Jeanie Bourke - Re: 616 Congress ST., B#2015-01687 plan review comments

From: Jeanie Bourke
To: Buell Heminway
Subject: Re: 616 Congress ST., B#2015-01687 plan review comments
CC: Thomas Barr III

RESTAURANT SEATING

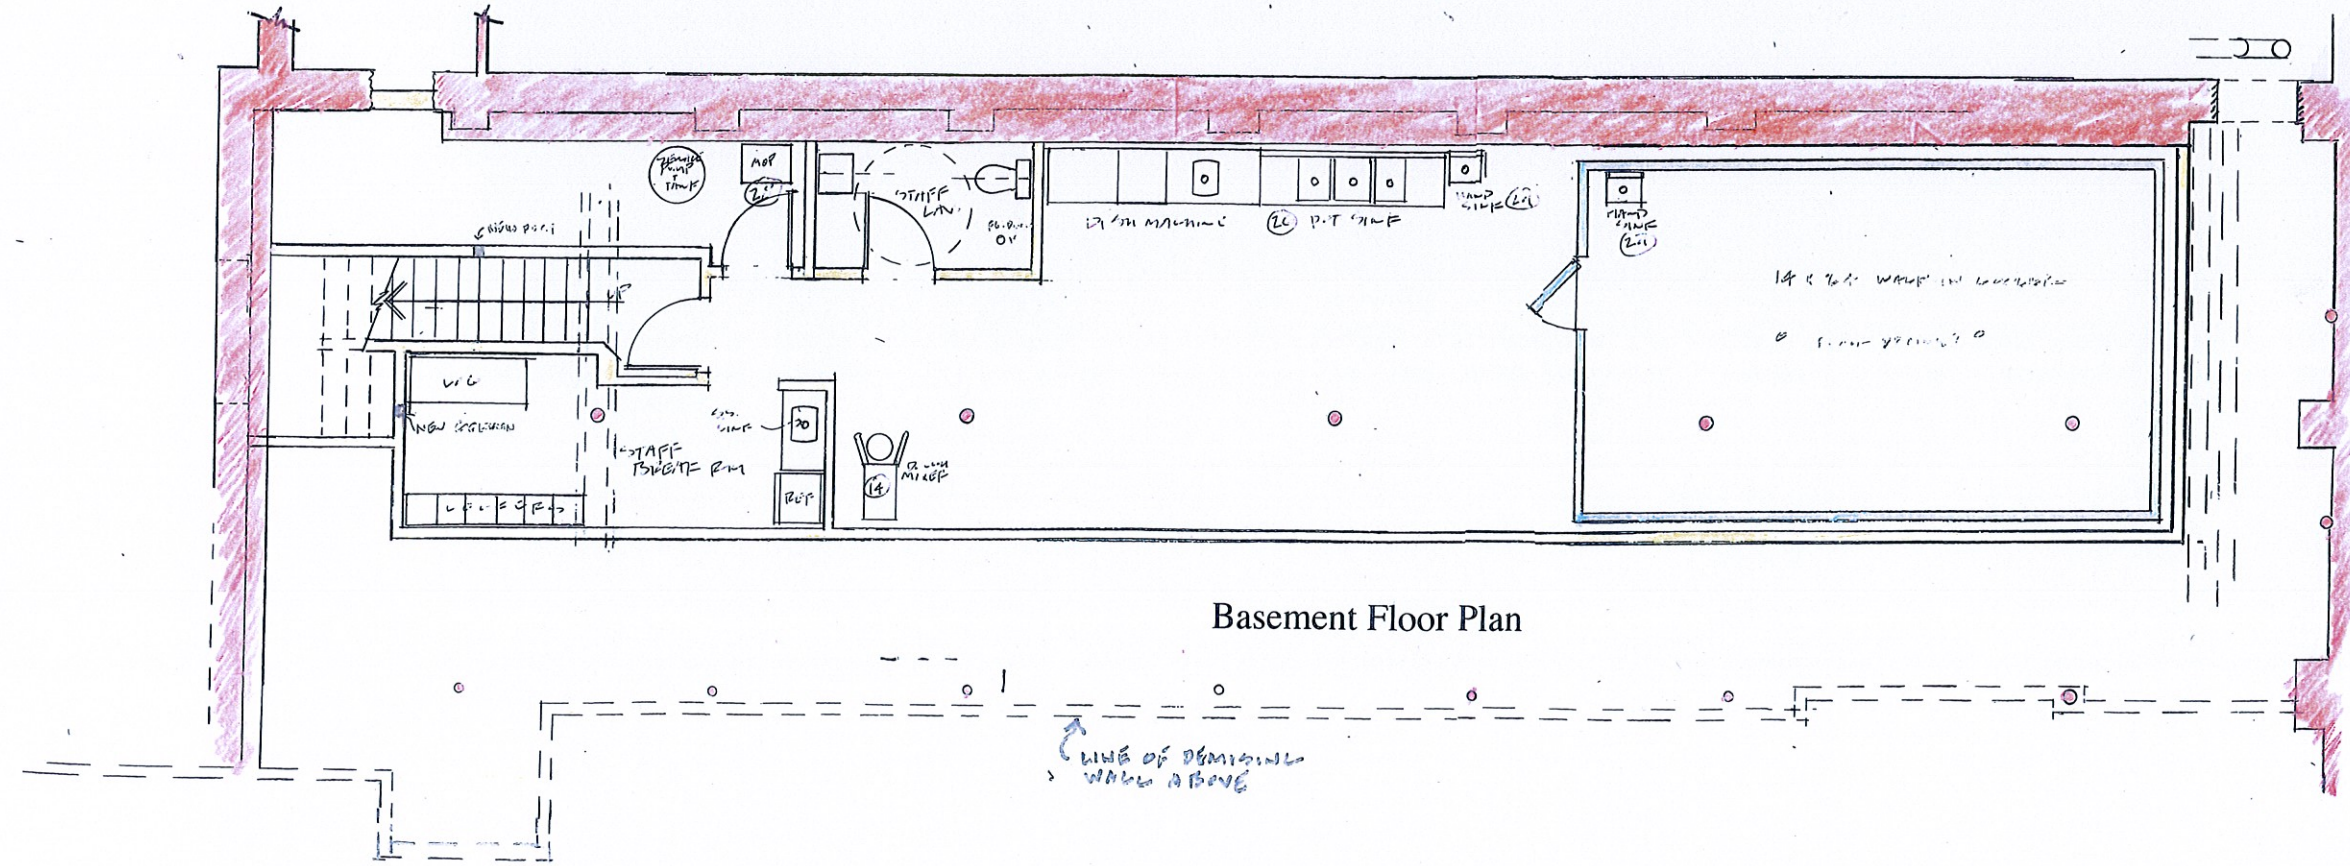
Thank you for submitting the seating plan with provisions for accessible seating. Based on the number of seats, this satisfies the 5% minimum requirement. Despite the bar seating, there is good dispersion of seats in all areas. As an alternative, you could consider providing accessible seats at the lunch bar.

One concern that will need your attention is the knee and toe clearances at the designated tables if customers remain in their wheelchairs or scooters, per Sec. 305 & 306 in the ADA standards.

I have reviewed the ADA accessibility requirements with my client Tom Barr and have developed the attached.

In the Lunch/Bar and Bar areas we endeavored to integrate accessible tables among adjacent surfaces which are 36" high.
The bar counter remains at 42" high due to the array of equipment on the service side.

Please note that all transactions are by server to patron, so no service/payment counters are contemplated.
